February 27, 2023

**Subject: Projection Repair Recommendations
 Lot No. 3 – (28 Drathaar Court)
 Griffon Pointe Subdivision
 Lillington, North Carolina
 Permit Number: 2209-0026
 SUMMIT Project Number: 0040.F0001 (37472-01)**

FOUNDATION PLAN – CRAWLSPACE
 SIDE LOAD GARAGE WITH 3RD CAR GARAGE OPTION
 ELEVATION A&C – OPTIONAL REC ROOM

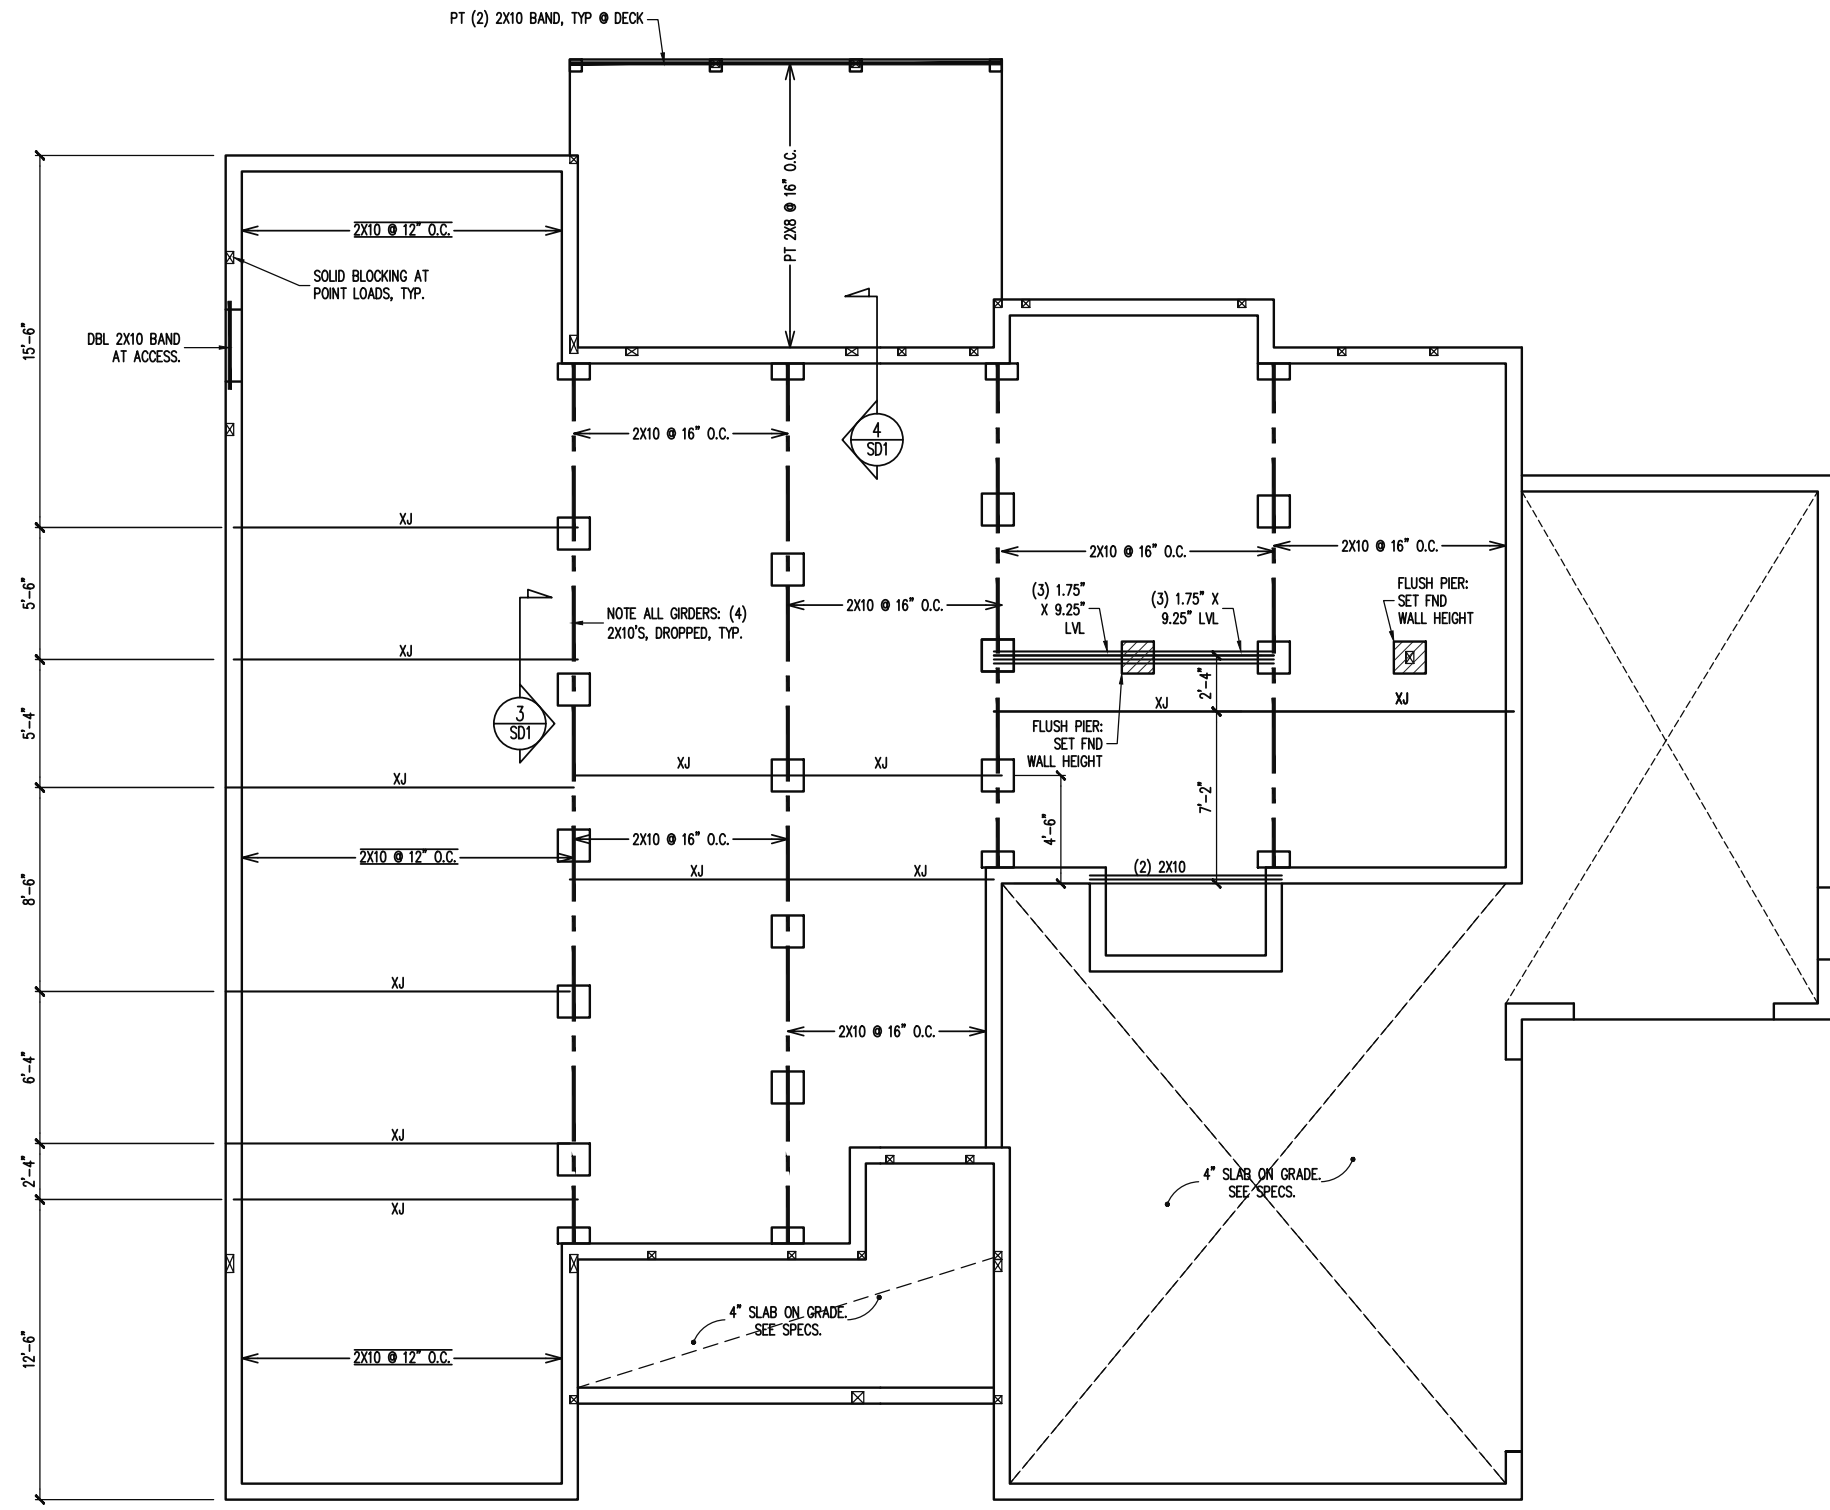
SUMMIT Engineering, Laboratory and Testing, Inc. (SUMMIT) was notified that projections were short around the middle of the left exterior foundation wall. We provide the following recommendations:

The new footing shall be a minimum of 10” deep, poured to match the existing footing depth. The new footing shall be secured to the existing footing with #4 rebar dowels spaced at a maximum of 12 inches on center with a minimum of 2 dowels per footing projection segment. The dowels shall be drilled and epoxied, mid-depth, with Simpson SET epoxy or equivalent. The dowel holes should be drilled perpendicular into the existing concrete and shall not be angled. The dowel hole for #4 rebar should be drilled with a 5/8” concrete bit. The rebar dowels shall have a minimum 3” cover and minimum embedment of 5” into both the new and existing footing. The epoxy shall be placed in a hole that is drilled and thoroughly cleaned per the manufacturer’s specifications.
